**From:** [Redacted]  
**To:** [MU1](#)  
**Cc:** [Redacted]  
**Subject:** 2021/1089 and 2021/1090 Reconsultation Forestry Officer  
**Date:** 15 December 2023 15:12:30  
**Attachments:** [image001.png](#)  
[image002.png](#)  
[image003.png](#)  
[image004.png](#)  
[image005.png](#)  
[image006.png](#)  
[image007.png](#)  
[image008.png](#)  
[image009.png](#)  
[image010.png](#)  
[image011.png](#)  
[image012.png](#)

**Subject:** 2021/1089 and 2021/1090

The arboricultural information provided relates to both the applications in the single document and as such rather than trying to split the elements I will provide comments on both applications and the documents provided singularly rather than for each separate application.

Figure 6 – Hedgerow Regulations Survey Plan

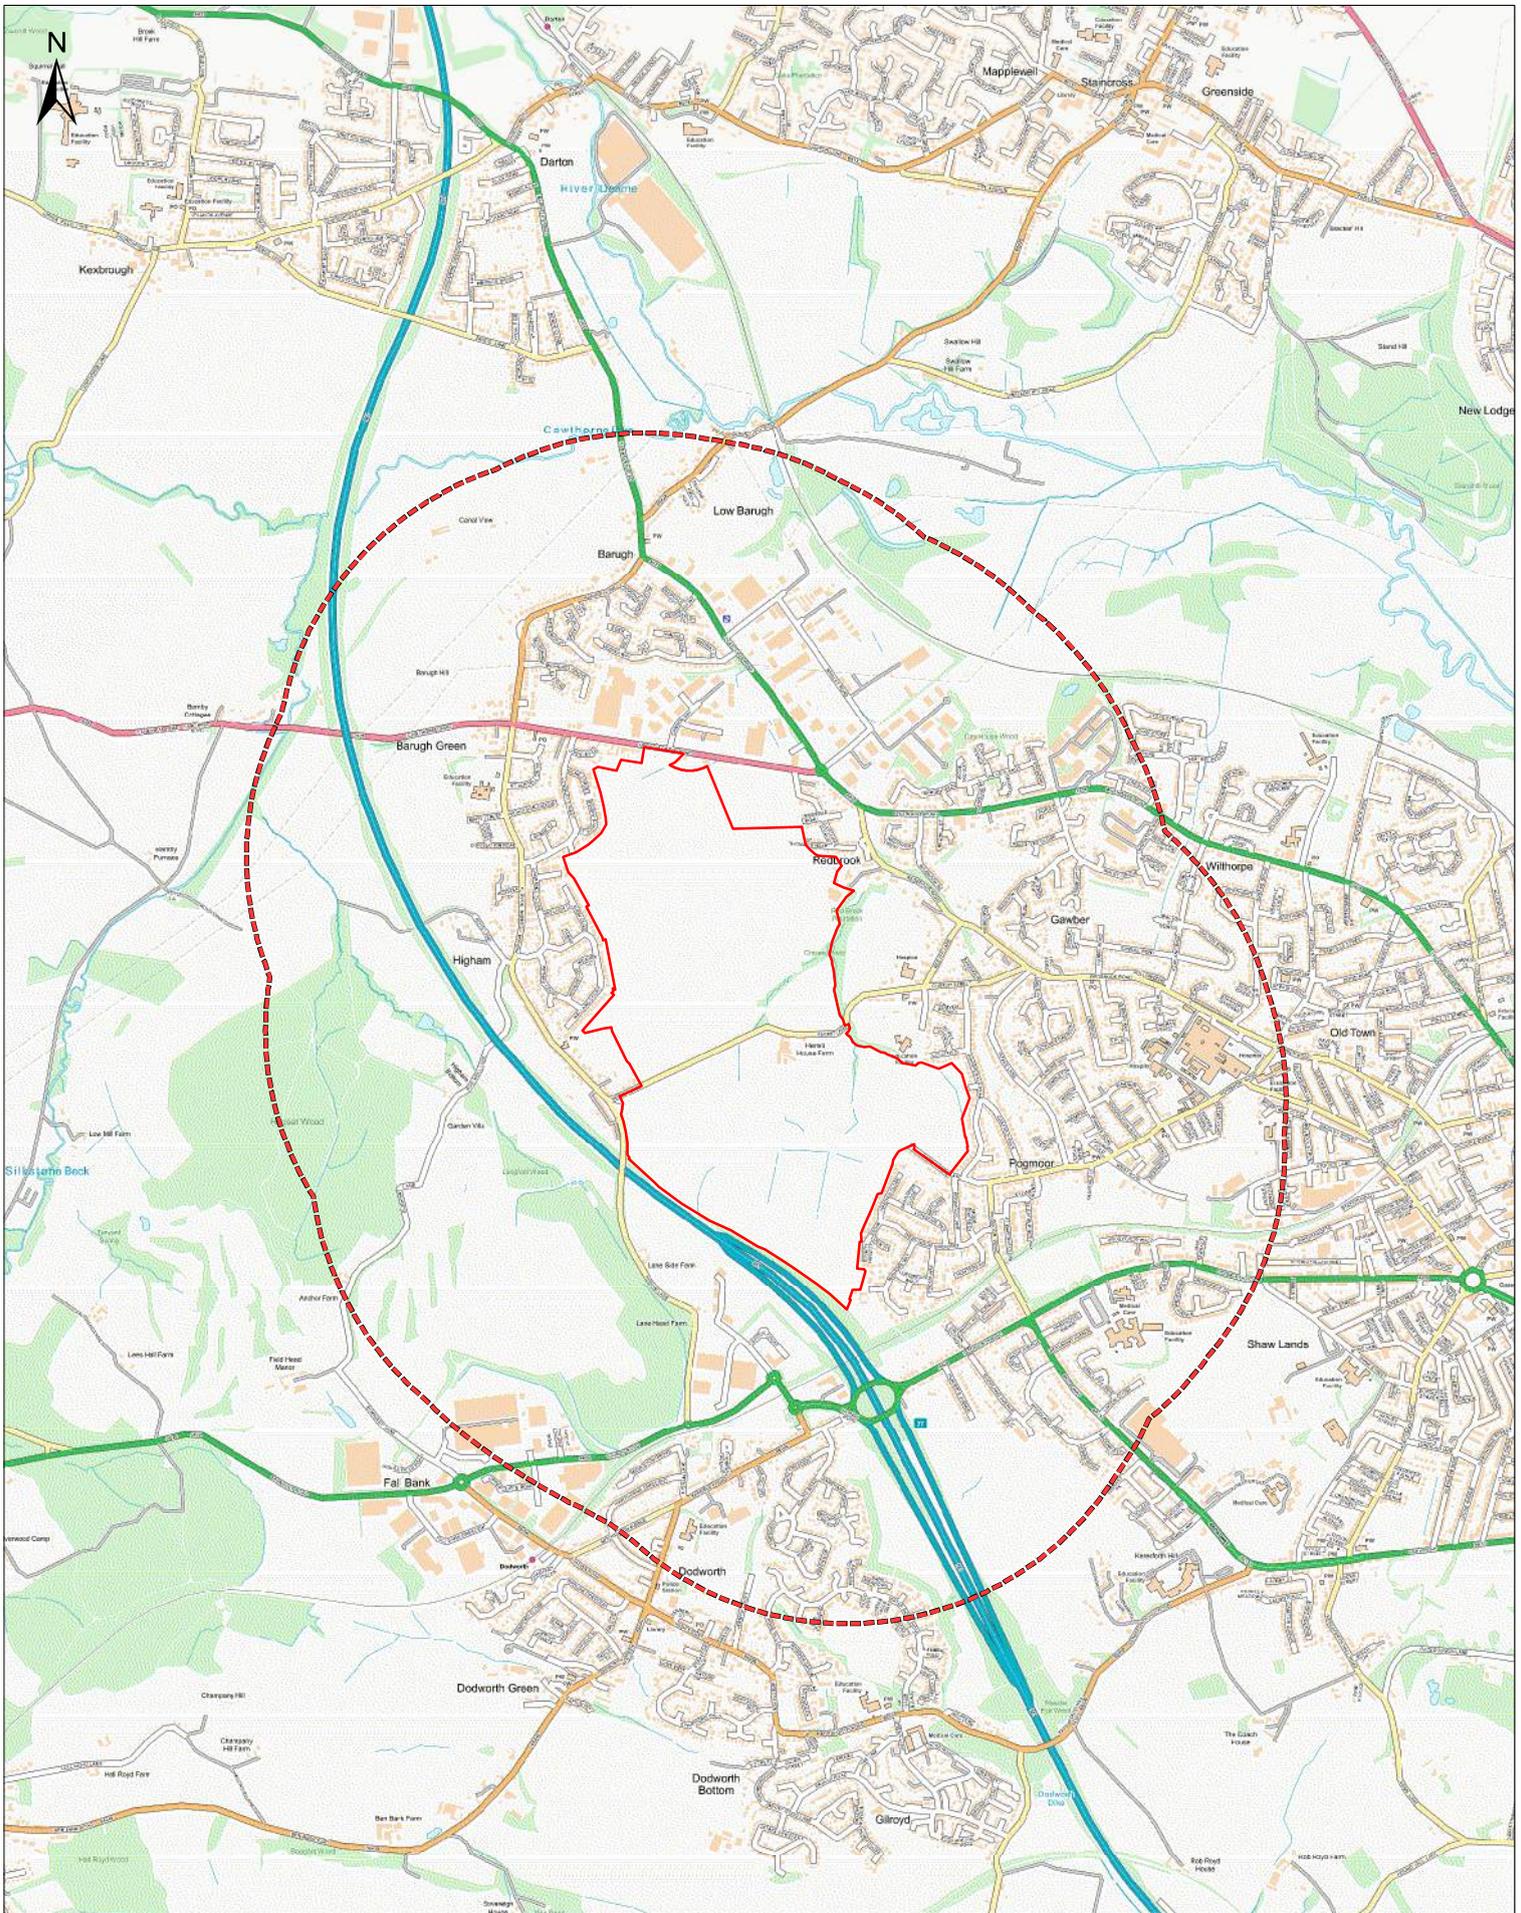
The Masterplan Framework notes that important hedgerows must be retained wherever possible and if not be translocated to a suitable location within the sites. Having read through the AIA no mention is made of the outcomes of the assessment of the hedges under the Hedgerows regulations 1997 and nor is there any mention of translocation of these hedges and how this will be achieved. This is key to the works involving the hedgerows and as such I feel it must be included in the AIA so the entirety of the Impacts on the trees, woodlands and hedges can be adequately assessed.

- The recommendations for amendments to the scheme noted in the AIA need to be looked at and acted upon
- Amendments to the proposals need to be looked into where trees are implicated by the proposed scheme for level changes on the edge of rooting areas or for hard surfacing etc.
- Amendments into the scheme need to be looked into where trees located in areas of open space are proposed to be removed/impacted upon.
- Undertake additional survey work required with regards to W1 etc.
- Include details of important hedgerows and how they will be translocated as required in the AIA
